# East Anglia TWO Offshore Windfarm

## Appendix 13.1 Commercial Fisheries Consultation Responses

### Environmental Statement Volume 3

Applicant: East Anglia TWO Limited  
Document Reference: 6.3.13.1  
SPR Reference: EA2-DWF-ENV-REP-IBR-000905\_001 Rev 01  
Pursuant to APFP Regulation: 5(2)(a)

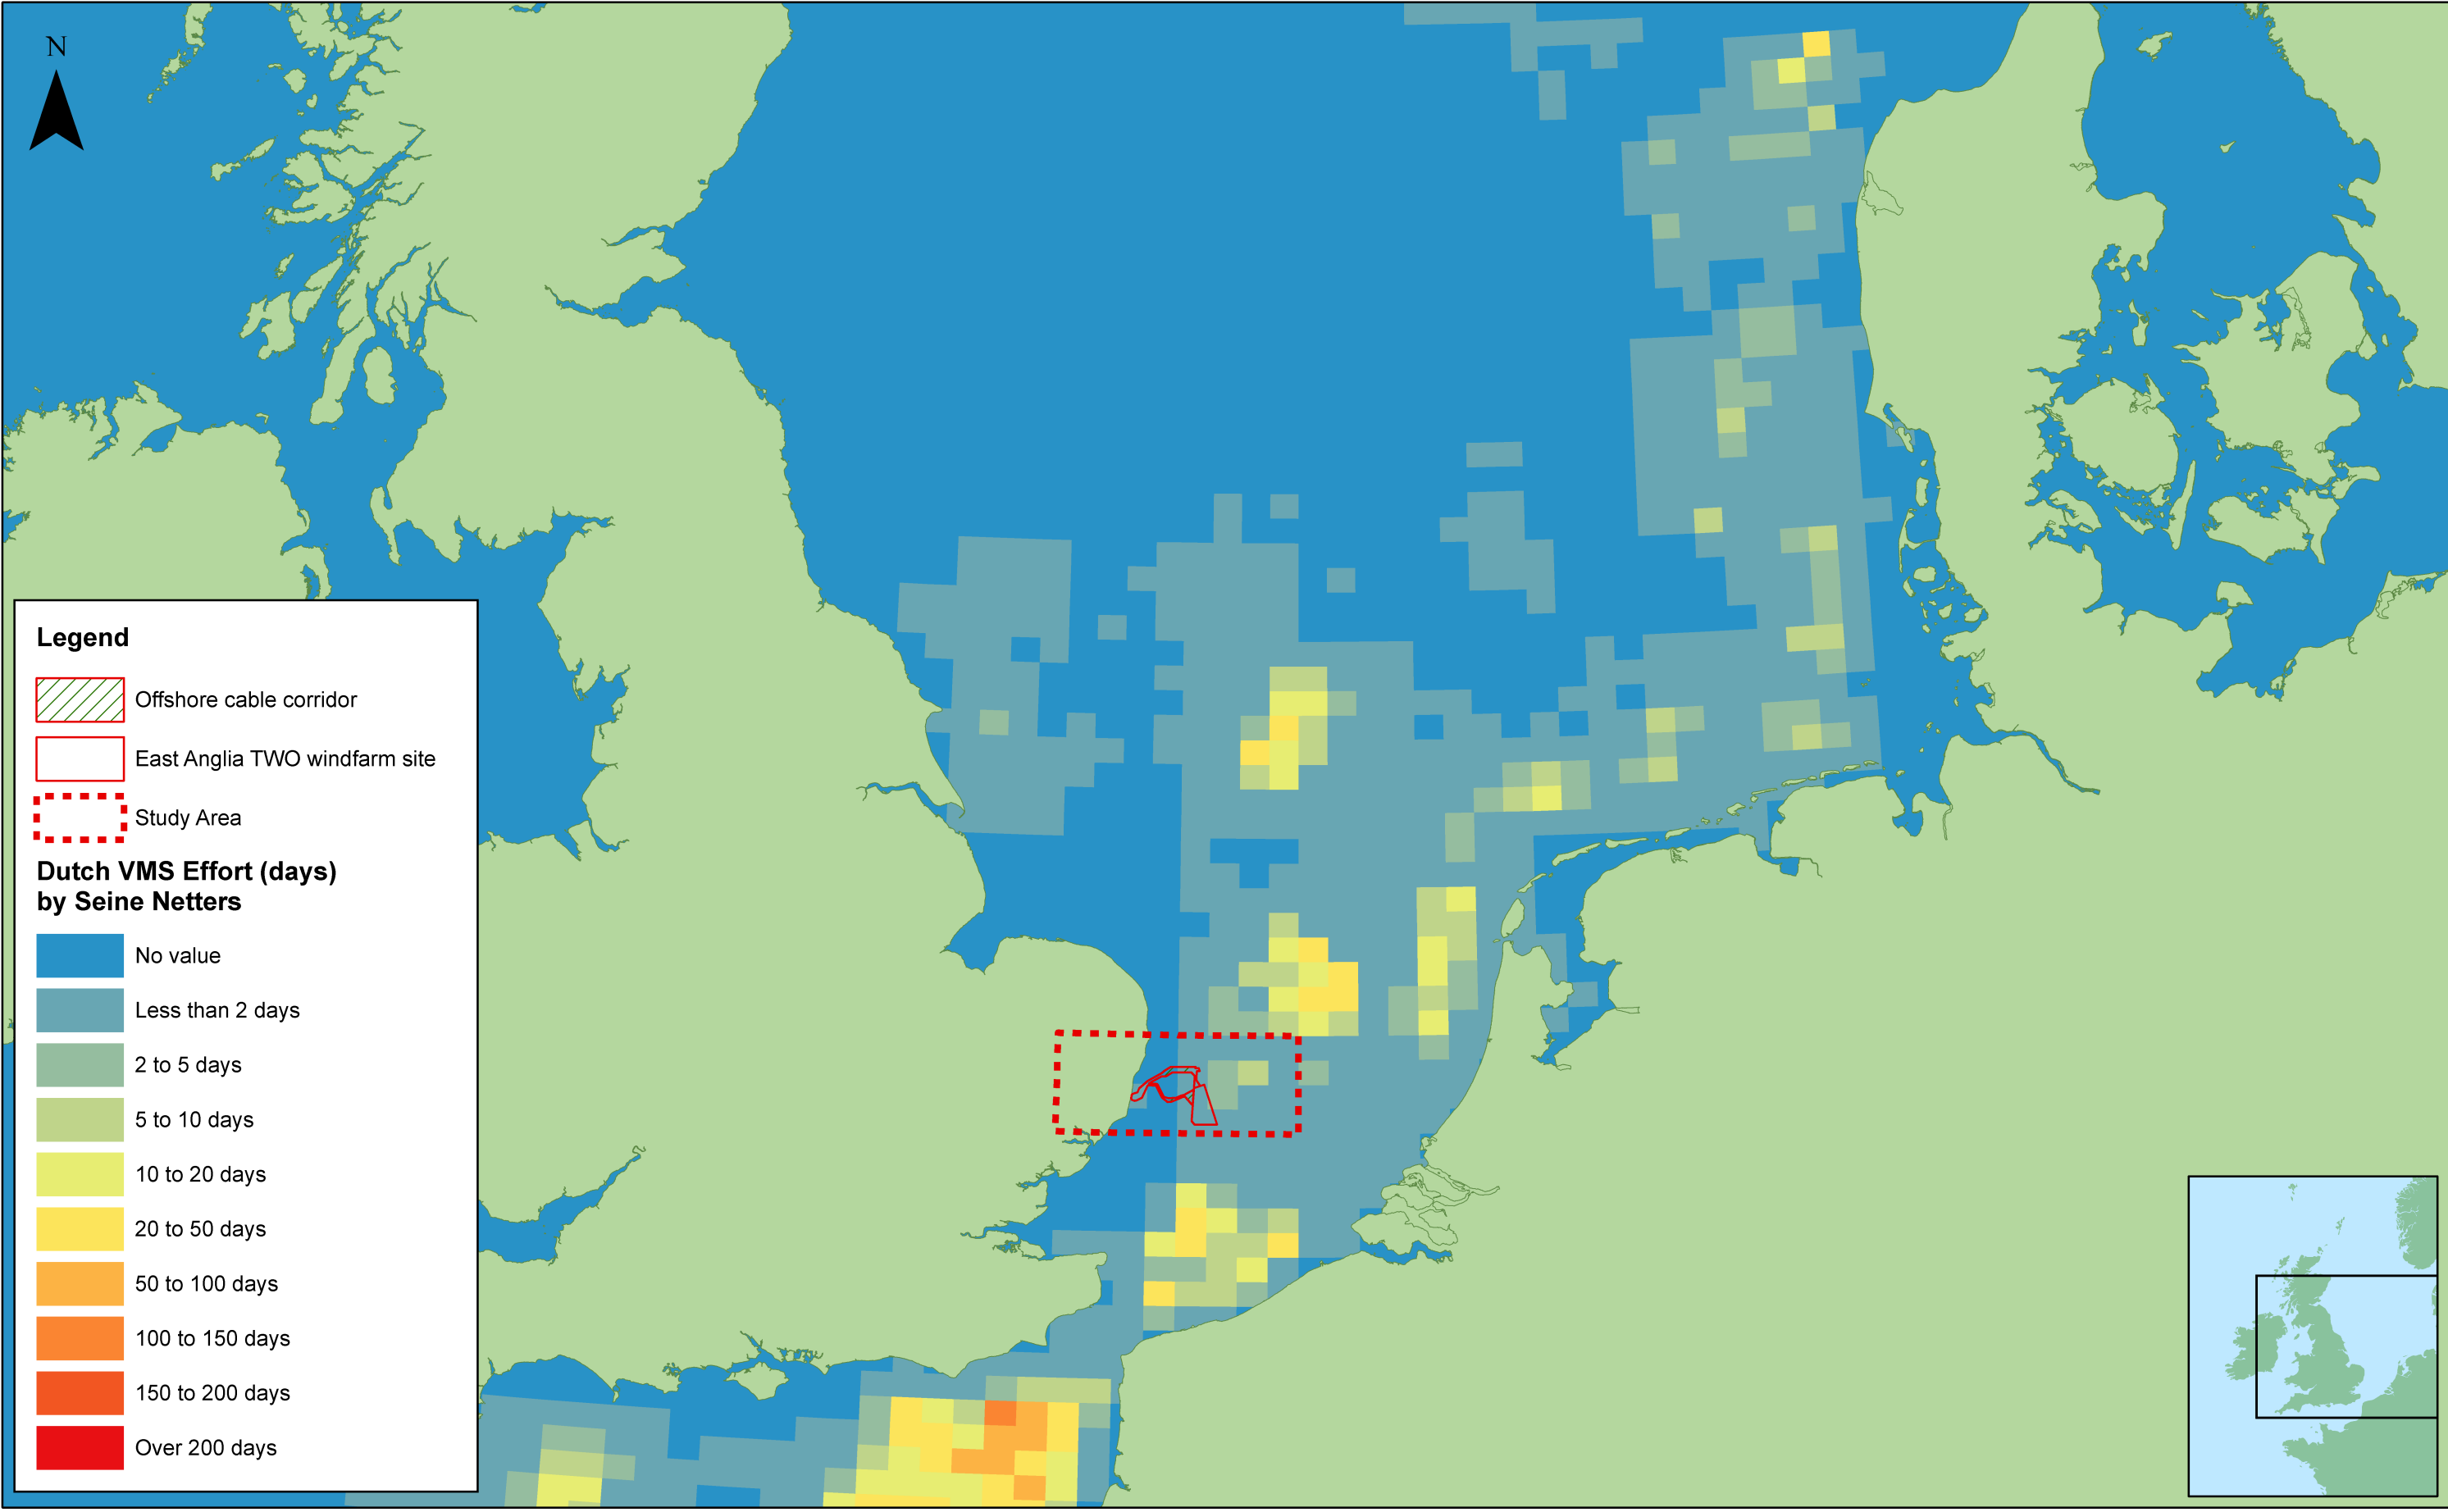
National Federation of Fishermen's Organisations/ VisNed	PEIR Response 26 <sup>th</sup> March 2019	The methodology does not provide a transparent assessment of compatibility of fishing activities taking place within the vicinity of the wind farms. We consider that under a fixed foundation scenario a minimum spacing of 1 km+ is needed for beam trawlers and 2km for seine netters is required for some level of fishing activity to co-exist in the vicinity of the array.	As noted in <b>Table 13.3</b> the minimum spacing between turbines proposed for the East Anglia TWO project is 800m in-row and 1,200m inter-row.  The assessment presented in this chapter therefore considers that beam trawling activity will be able to resume to some extent during the operational phase within the East Anglia TWO windfarm site.  With regard to seine netting, in recognition of the practicalities of operating this gear type within wind farm arrays and considering the worst case minimum spacing, the assessment presented in this chapter assumes that that vessels operating seine nets may not be able to resume activity within the operational East Anglia TWO windfarm site.
